# PEERLESS FARMS PRELIMINARY PLAN 16975 FALCON HIGHWAY, PEYTON, CO

**COVER SHEET**  
**SHEET 1 OF 3**

PRELIMINARY PLAN  
SHEET 2 OF 3

# V2\_Preliminary Plan Drawings.pdf Markup Summary

1 ALTERNATIVE HAMMERHEAD/PRIVATE FENCE LAYOUT DETAIL
TYPICAL TURN ROUND

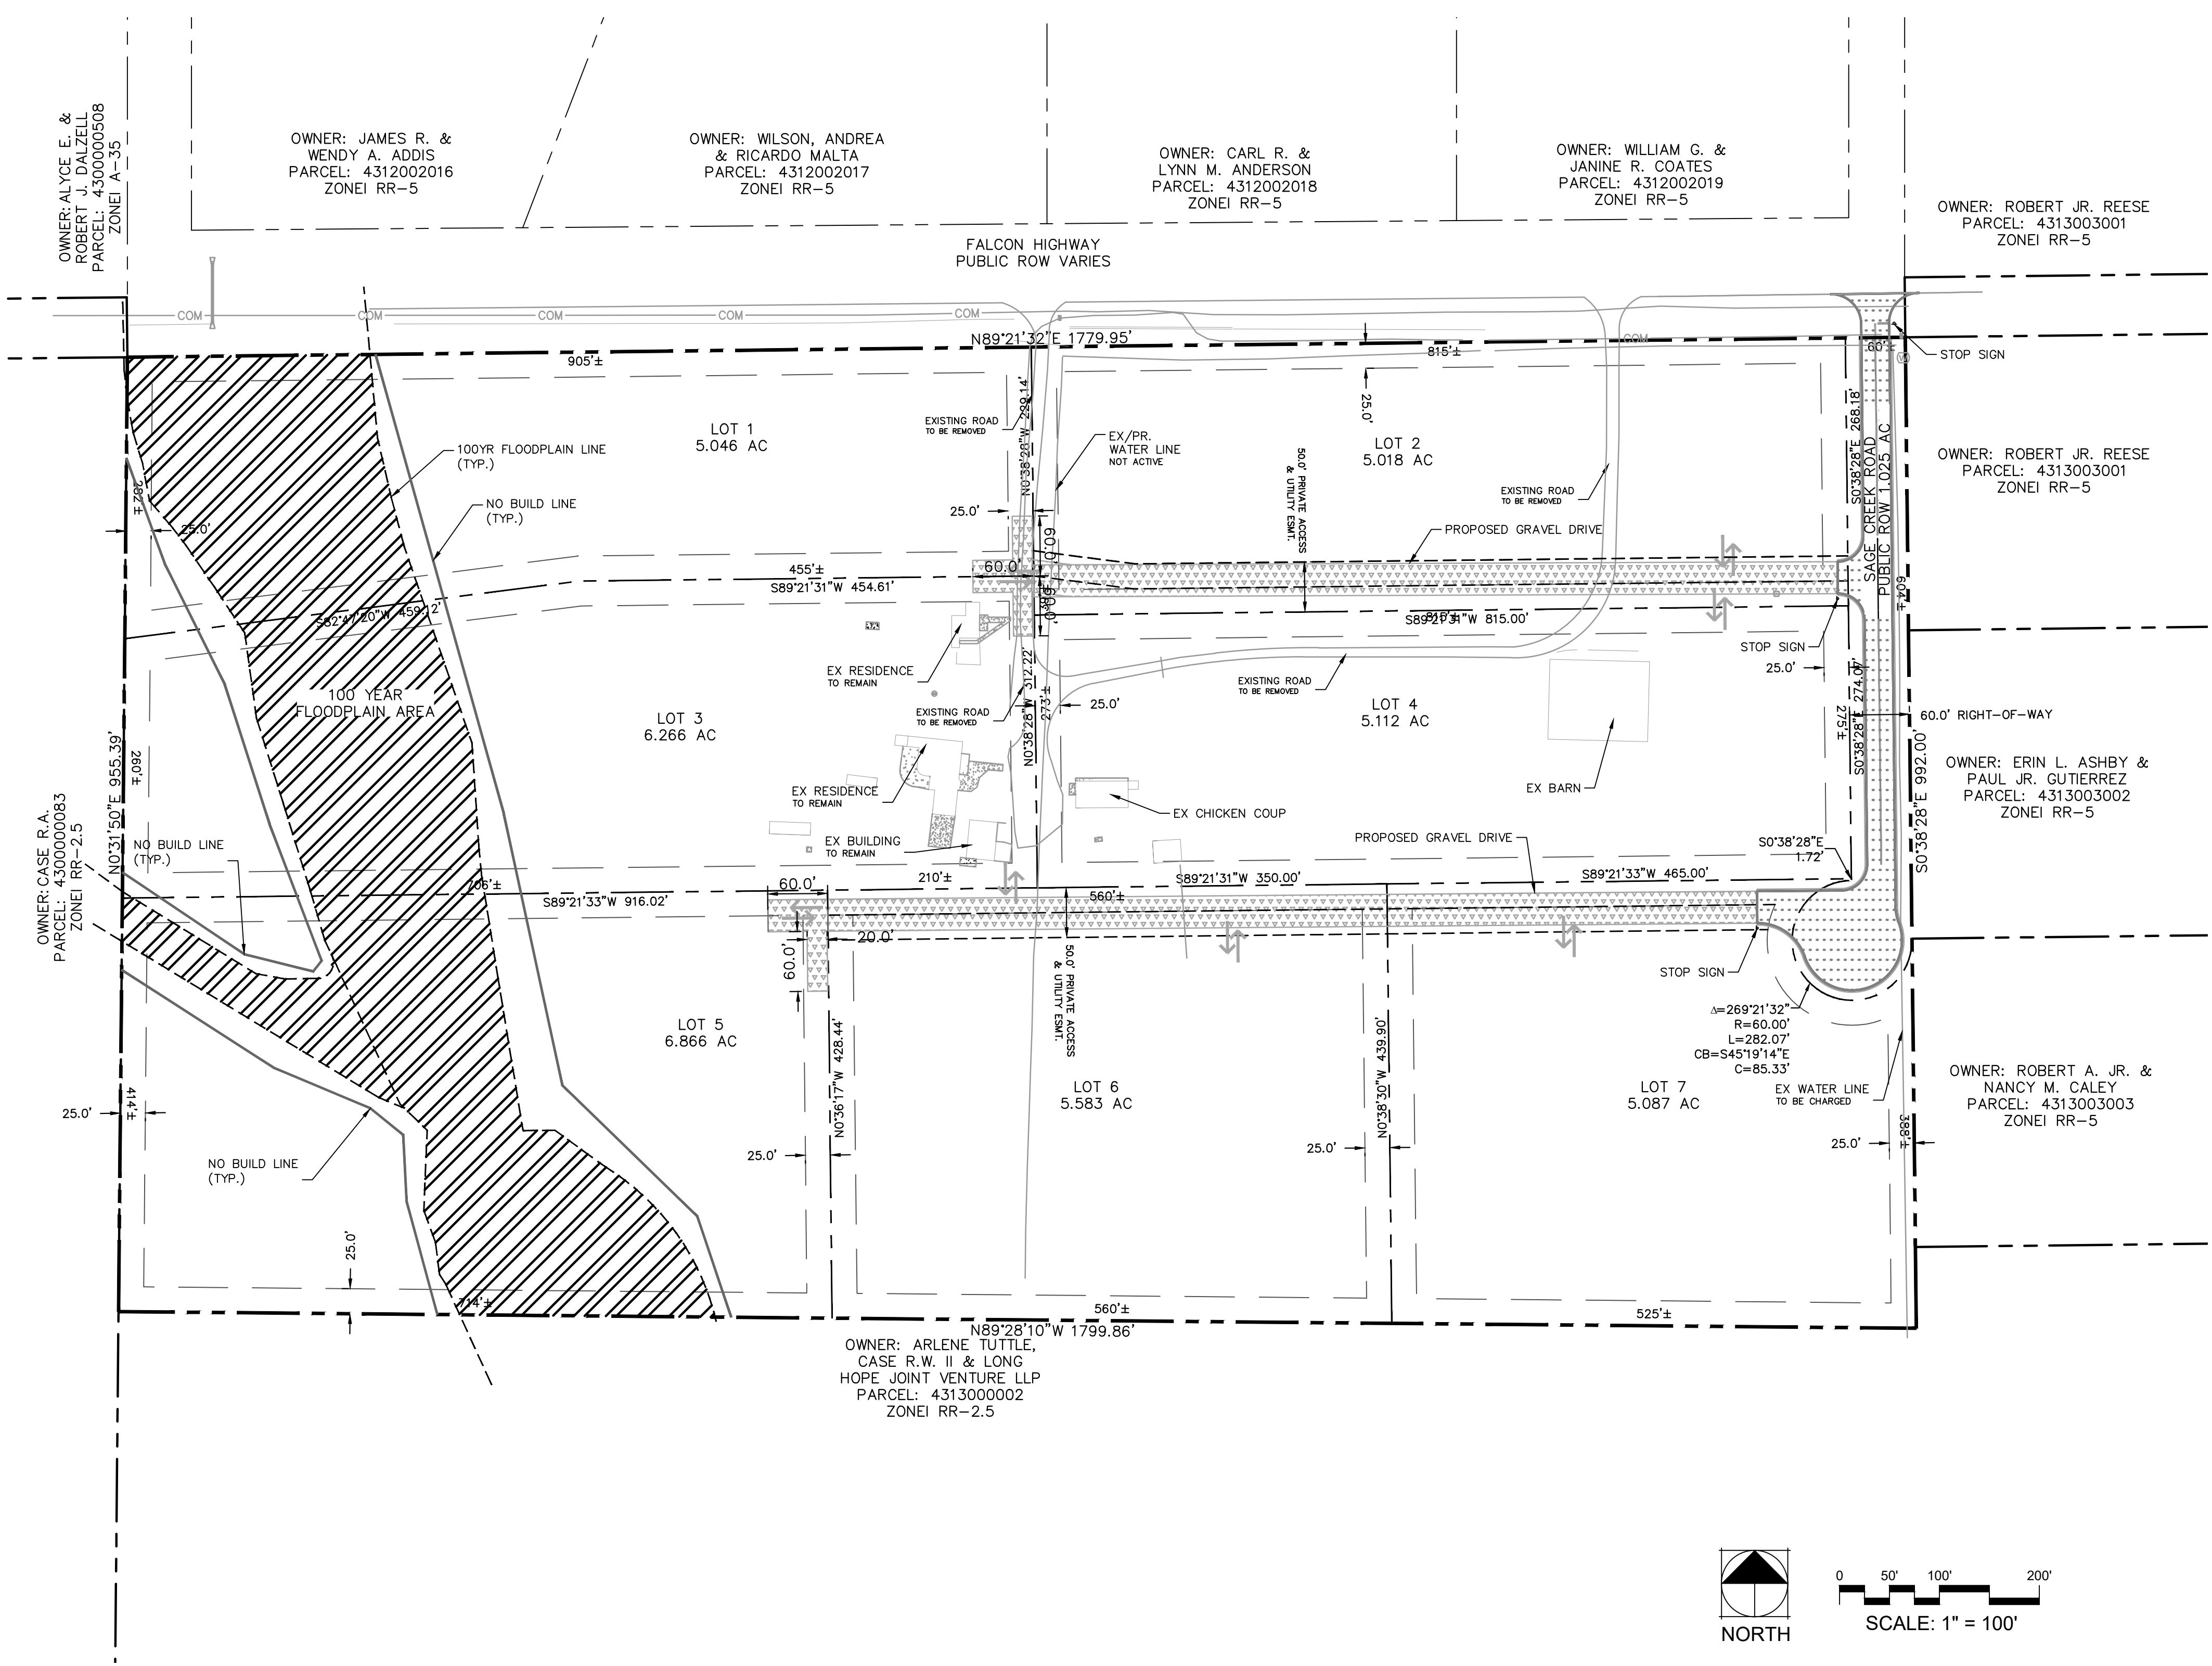
Add callout that cul-de-sac shall be built to EPC Standard Detail Drawing SD\_2-76

Label radius and right-of-way of cul-de-sac.

Label 60ft ROW and 5' foot public improvement easements.

LOI calls this a second residence

What is this building? It looks like it may be encroaching slightly into the proposed 25 ft setback

Seasonal wet areas should be included as no-build  
 areas or tracts.

What is this label?

If you are going to propose four lots accessing off of this, then it can't be a driveway - it must be a road. Roads will need to be named.

Please verify and revise FEMA Floodplain Baseflood Elevations. It appears base flood elevations are not shown and contours do not match with FIRM map.
